June 3, 2016

Bayside Bowl

Permit Review Comments Responses

**A5-4**

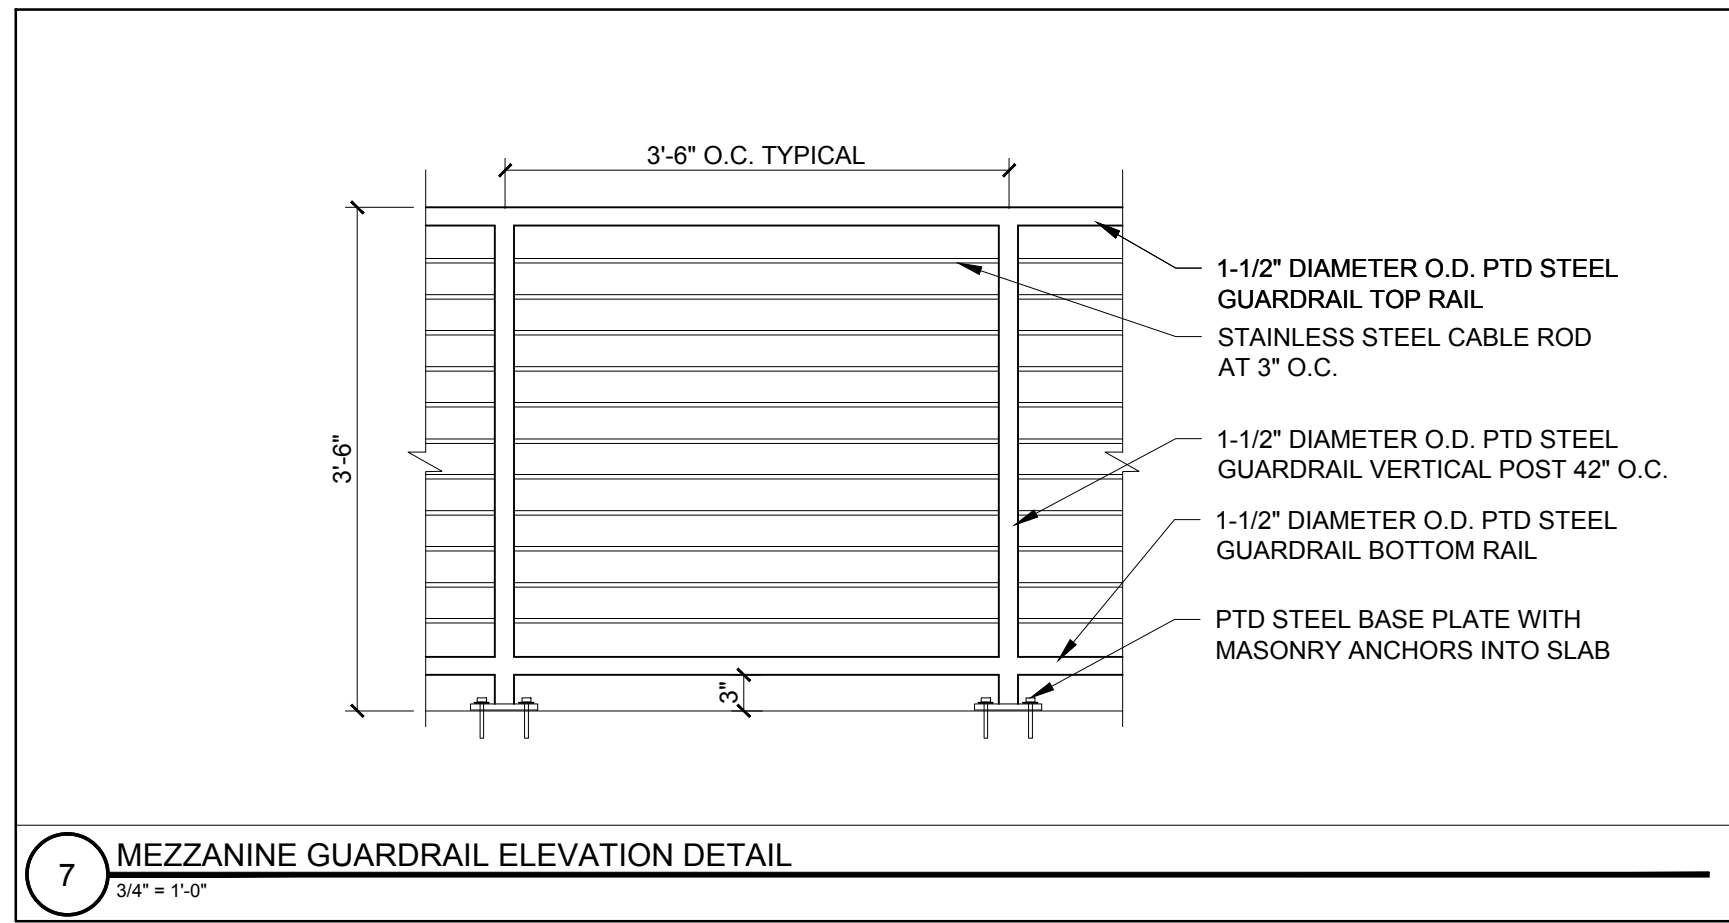
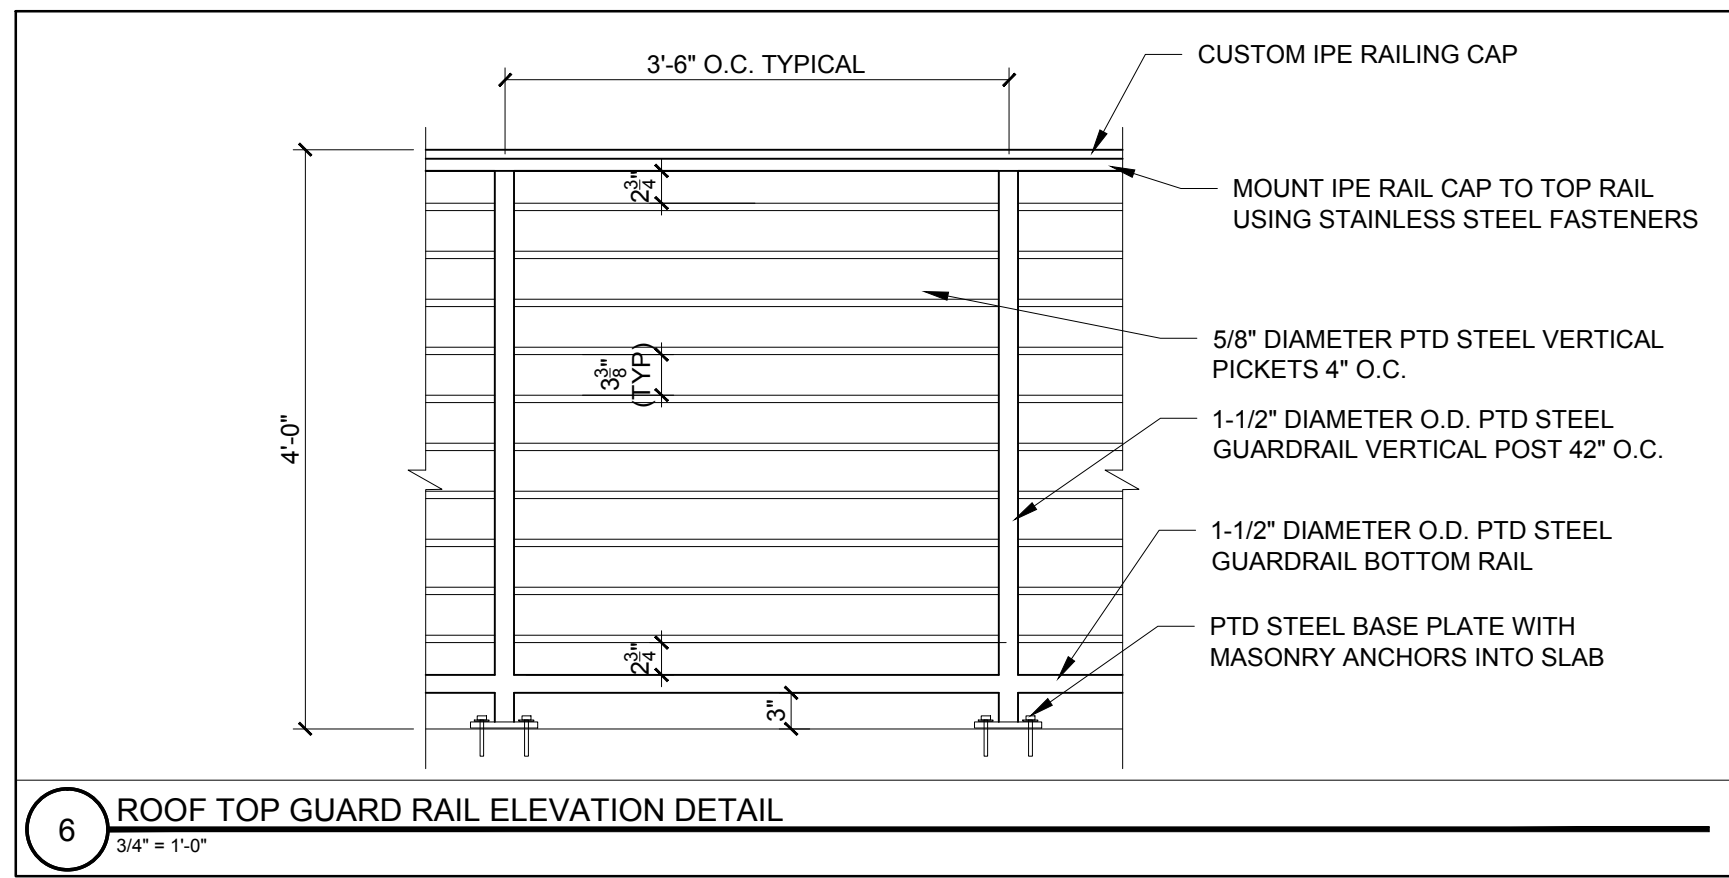
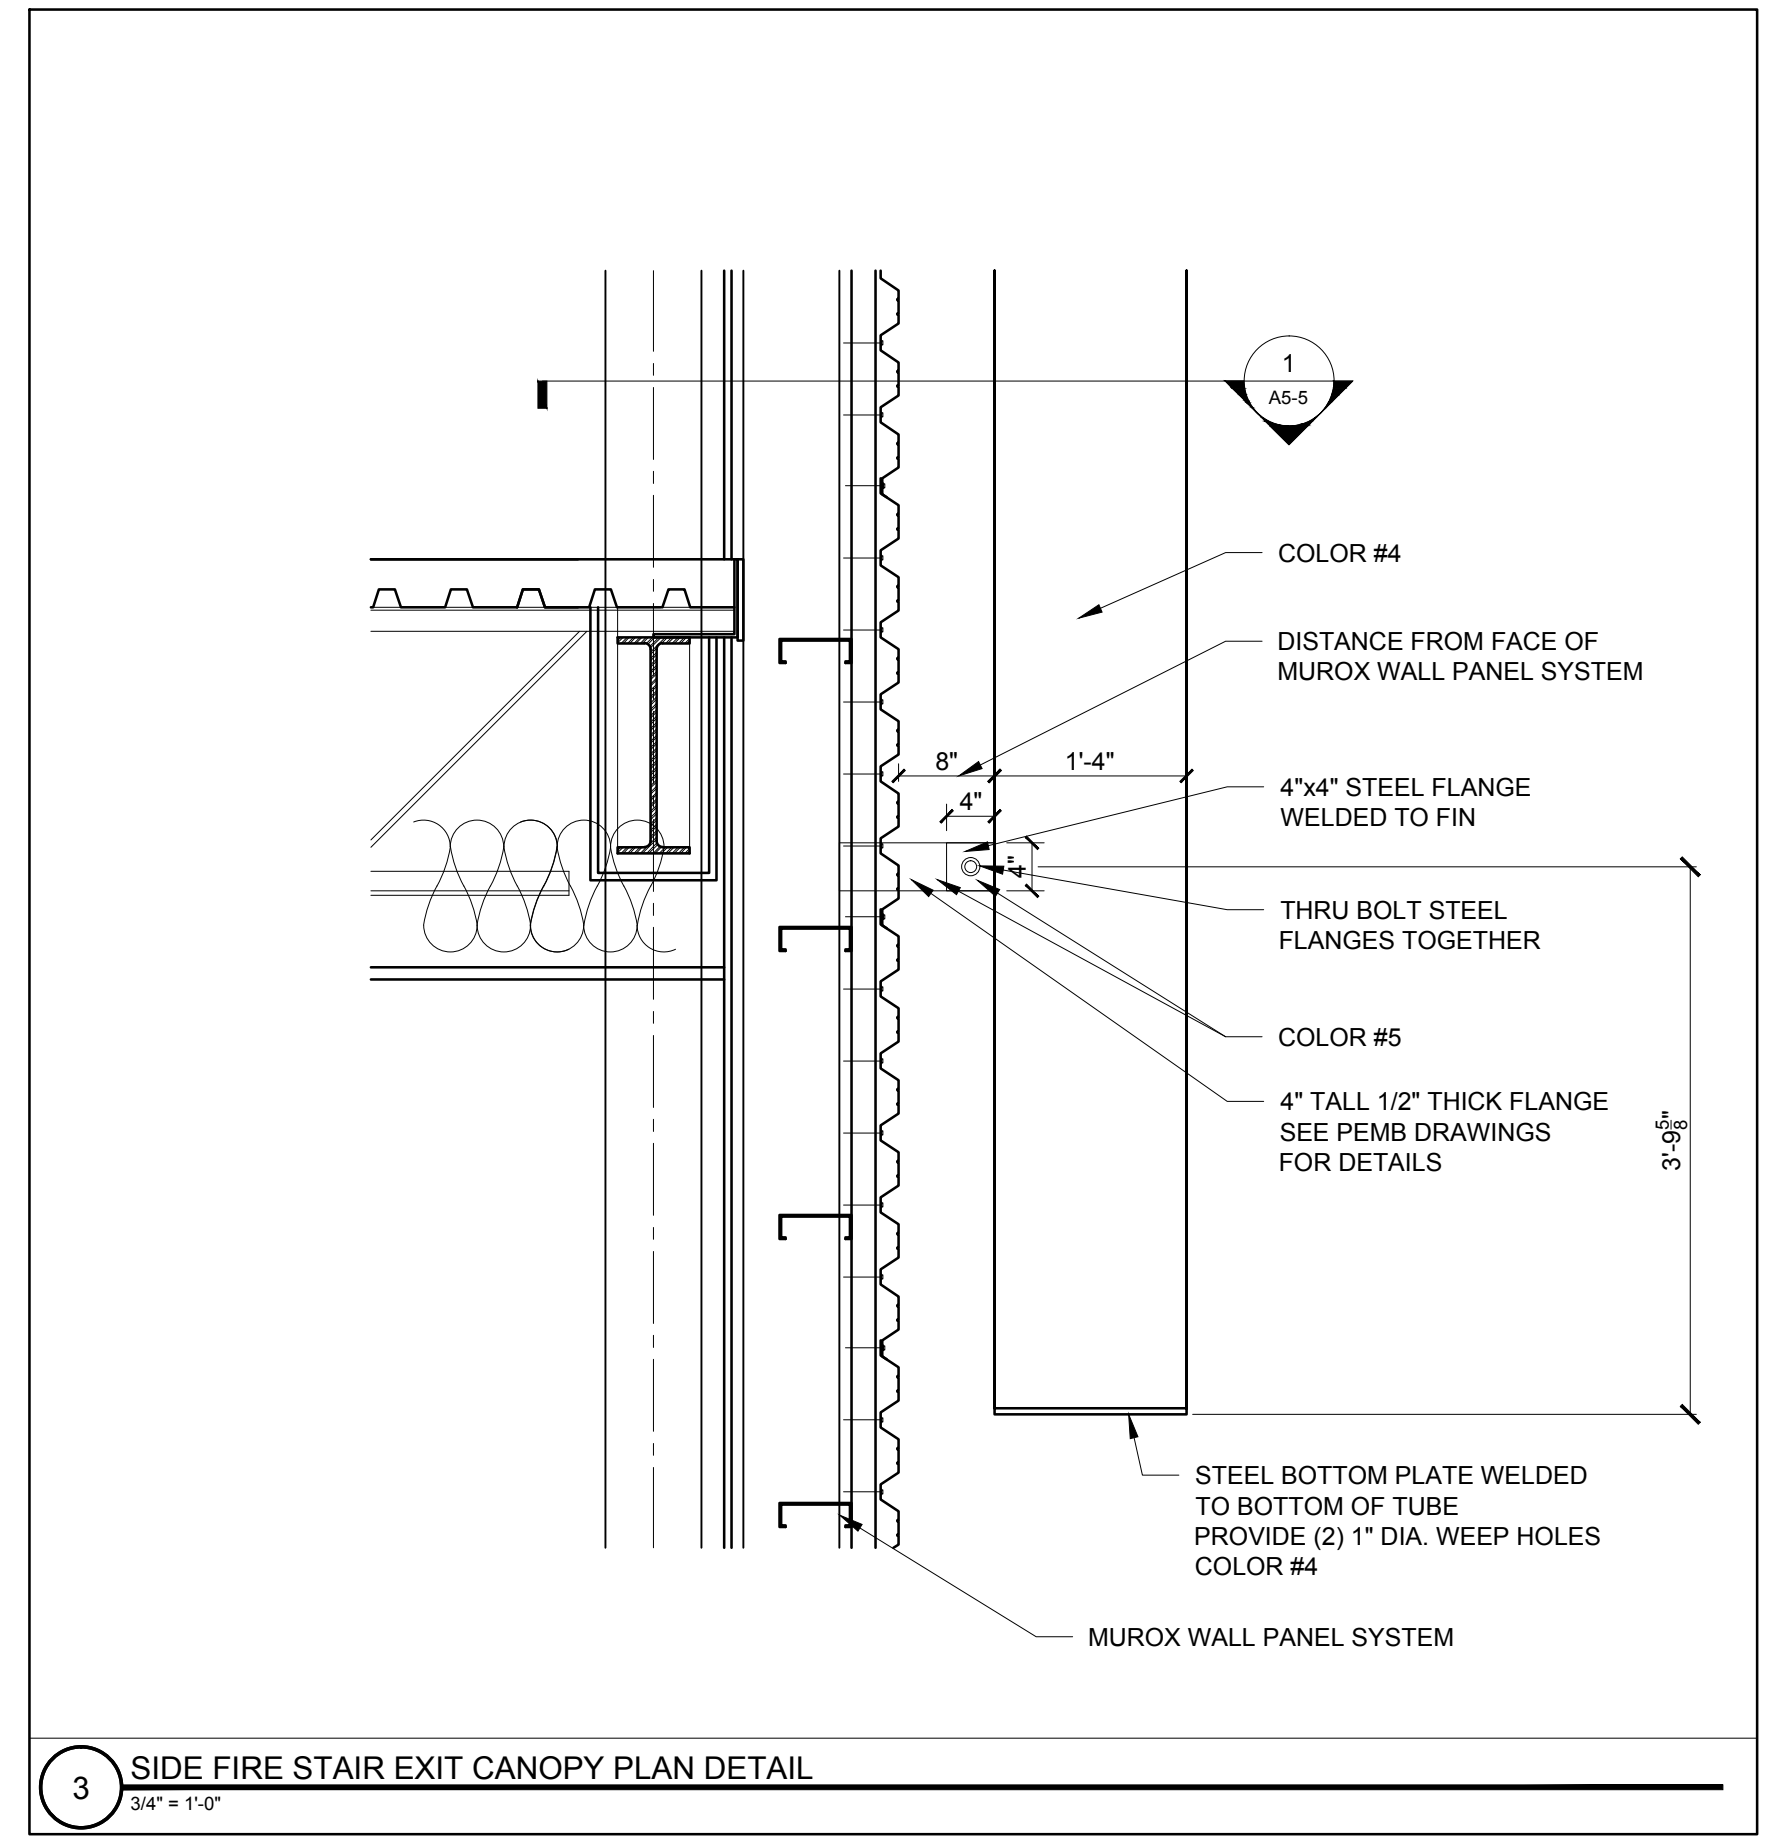
- 7.) A5-4. the Stainless Steel Cable rail system will be 3/16" diameter cable with tightening turnbuckles spaced at each end of the cables, to maintain tightness.
